**Re: Porch Plan Review & Structural Specifications**

104 Sherman Pines Dr, Fuquay-Varina, NC 27526 - Harnett Co.  
Project #: 23091 - Revision 2-8/4/23

TITLE:
**HOBBS COVERED DECK
(OPTION 3)**

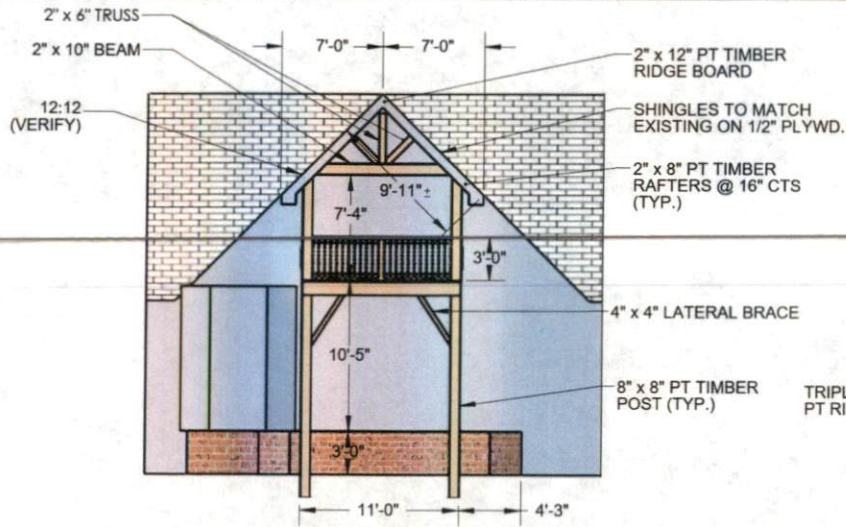
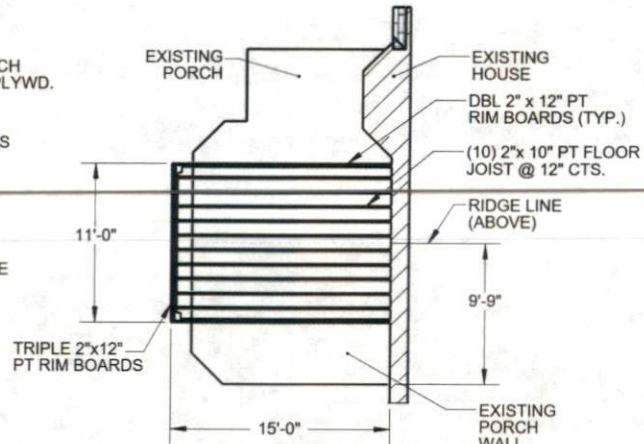
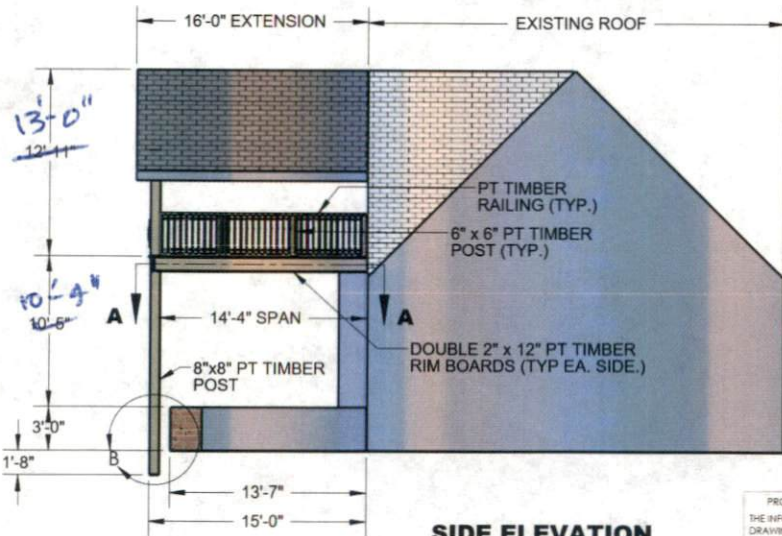
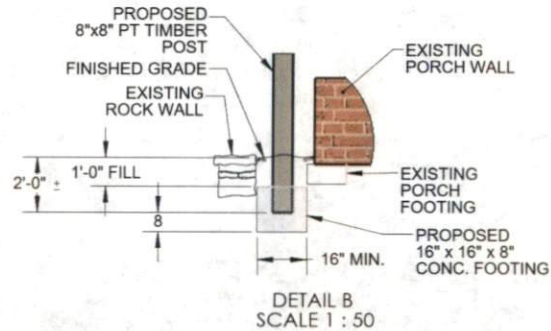
1. The structure being reviewed is a proposed second floor deck and porch addition to an existing home. The porch dimensions are 11'x15' with a cathedral ceiling.

2. Required Roof Framing Specifications:
  - 2x8 Rafters @16" O.C. may be used for the porch rafters.
  - A single ply 1.75"x11.25" LVL ridge beam shall be used to support the rafters.

- Support the interior end of the ridge beam with face mount hanger attached to the exterior sheathing at a stud location or to solid blocking between studs.

- The porch headers along the eave sides of the porch roof shall be a 2-ply 2x10. The porch header at the gable end of the porch shall be a 3-ply 2x10.

- Support the eave roof headers at the existing exterior wall with a 2-ply 2x4 stud column. Support the headers at the exterior edge with 8x8 P.T. posts.

- Attach headers to top of post using (4) 3/8"x6" lag screws or (4) SST (Simpson Strong-Tie) SDWC15600 truss screws drilled from the side of the post up into the underside of the header at a 60° angle.

- Provide solid blocking between joists below the 8x8 posts and secure posts to blocking/deck band w/(4) 3/8"x6" lag screws or (4) SST SDWC15600 truss screws. Refer to the post blocking detail at the end of this report.

3. Required Deck Floor System Framing:
  - Deck floor joists shall be P.T. 2x10's @12" O.C.
  - Attach a 2x12 ledger board to the existing house using the ledger attachment detail at the end of this report.

- Floor joists may be supported at the ledger using a 2x2 P.T. ledger strip attached with (3) 16d nails @ 12" O.C. Alternatively, SST LUS210Z face mount joist hangers (or equivalent product) may be used in lieu of the ledger strip.

- Support the deck joists at the outer edge of the deck with a 3-ply 2x12 P.T. deck band. Joists shall be supported at the deck band by attaching a 2x2 P.T. ledger strip with (3) 16d nails @ 12" O.C. Alternatively, SST LUS210Z face mount joist hangers (or equivalent product) may be used in lieu of the ledger strip.

- 8x8 P.T. support posts shall have "Y" bracing attached at each corner parallel with the rear wall of the house. Refer to the "Y" bracing detail attached at the end of this report.

- Bolt deck band to the 8x8 posts per the deck band/post attachment detail at the end of this report.
4. Foundation Requirements:

- The 8x8 posts shall be supported according to the footing detail located at the end of this report.
